From: Laura Gibbons <Laura.Gibbons@arun.gov.uk>
Sent: 12 October 2021 09:16
To: Planning.Responses <Planning.Responses@arun.gov.uk>
Cc: Michael Eastham <Michael.Eastham@arun.gov.uk>
Subject: RE: Planning Consultation on: BN/127/21/DOC

Application No: BN/127/21/DOC

Site Address: Land At Angels Nursery Yapton Road Barnham PO22 0AY

Description of Works: Approval of details reserved by condition imposed under BE/84/20/PL relating to conditions 3-as built drawings of implemented SuDS scheme & 5-updated copy of management manual or confirmation that no changes are required to manual.

124 mm QR4F Type Vortex Flow Control

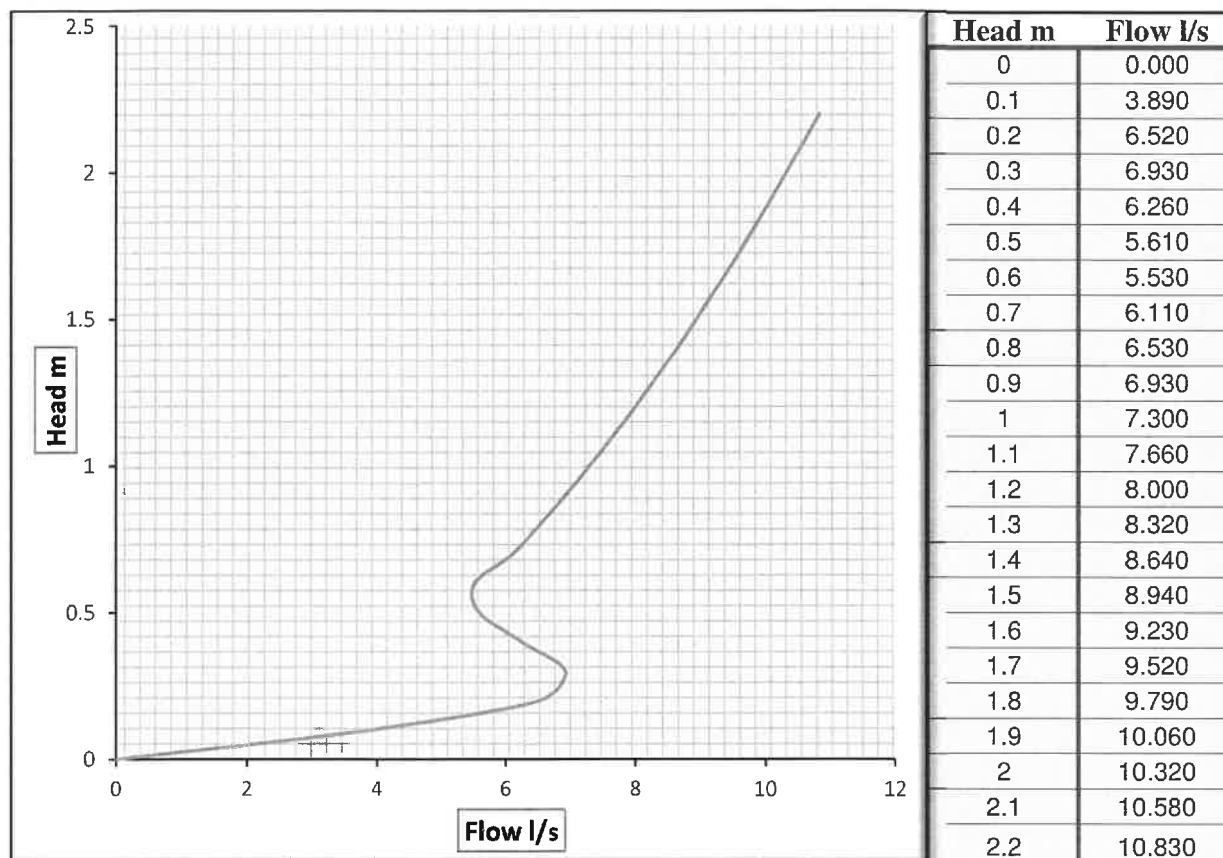
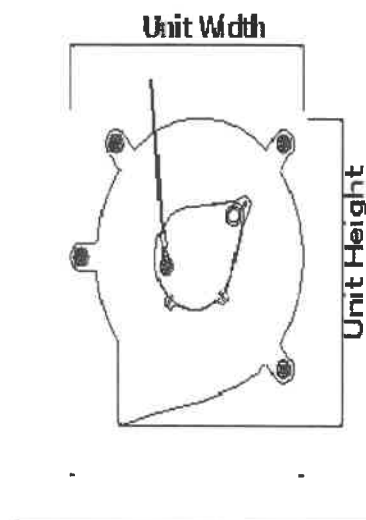
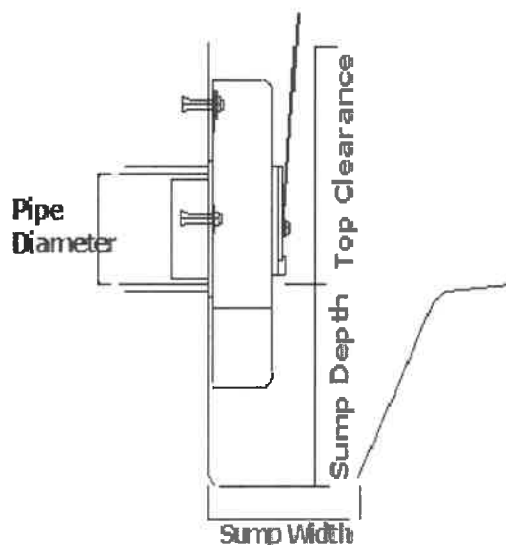
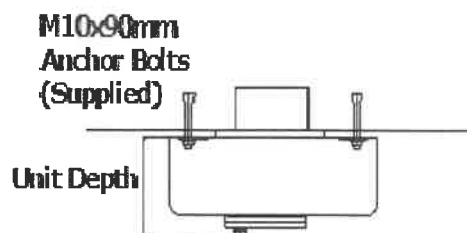
Please supply evidence that the appropriate flow control devices have been installed as per the design.
